Location: 98 Ribchester Road and land adj 94 Ribchester Road Clayton-Le-Dale BB1 9HQ
Proposal: Approval of details reserved by conditions 4 (Construction Management Plan), 5 (site access and off-site works), 9 (SW drainage), 12 (drainage scheme) and 14 (landscaping) of planning application 3/2024/0302.

APPLICATION NO. 3/2024/0996

DECISION DATE: 8 August 2025

PROPOSED DRAINAGE LAYOUT

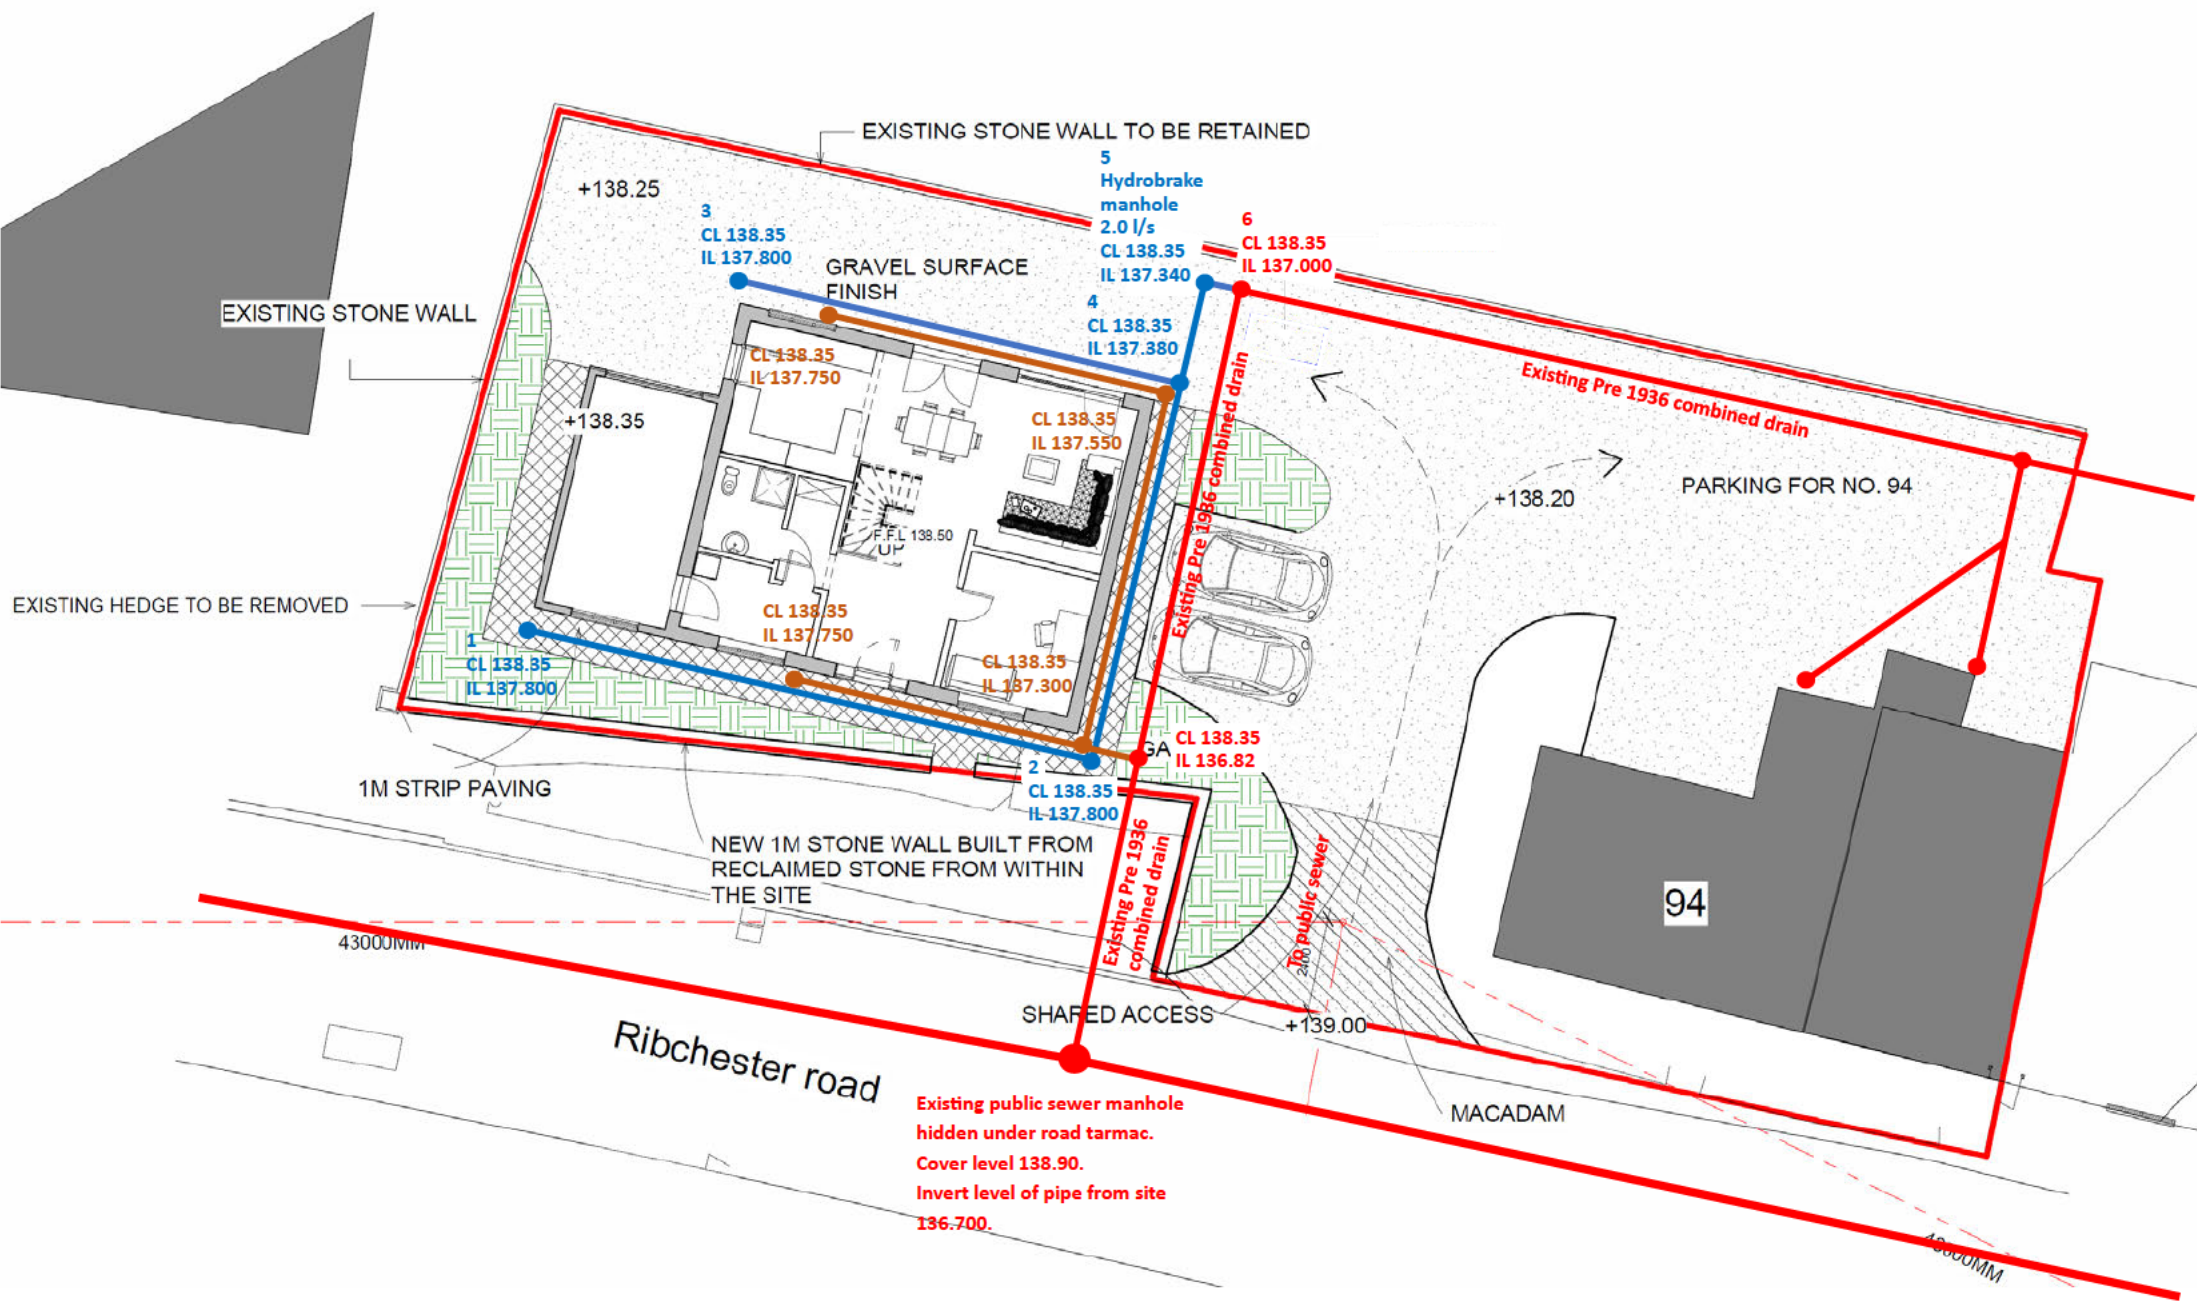
Condition 12 (Drainage scheme) cannot be discharged as insufficient details have been provided in terms of the drainage scheme with regards to the connection with the public wastewater network and a drainage survey to confirm that the foul sewer is a public combined sewer.
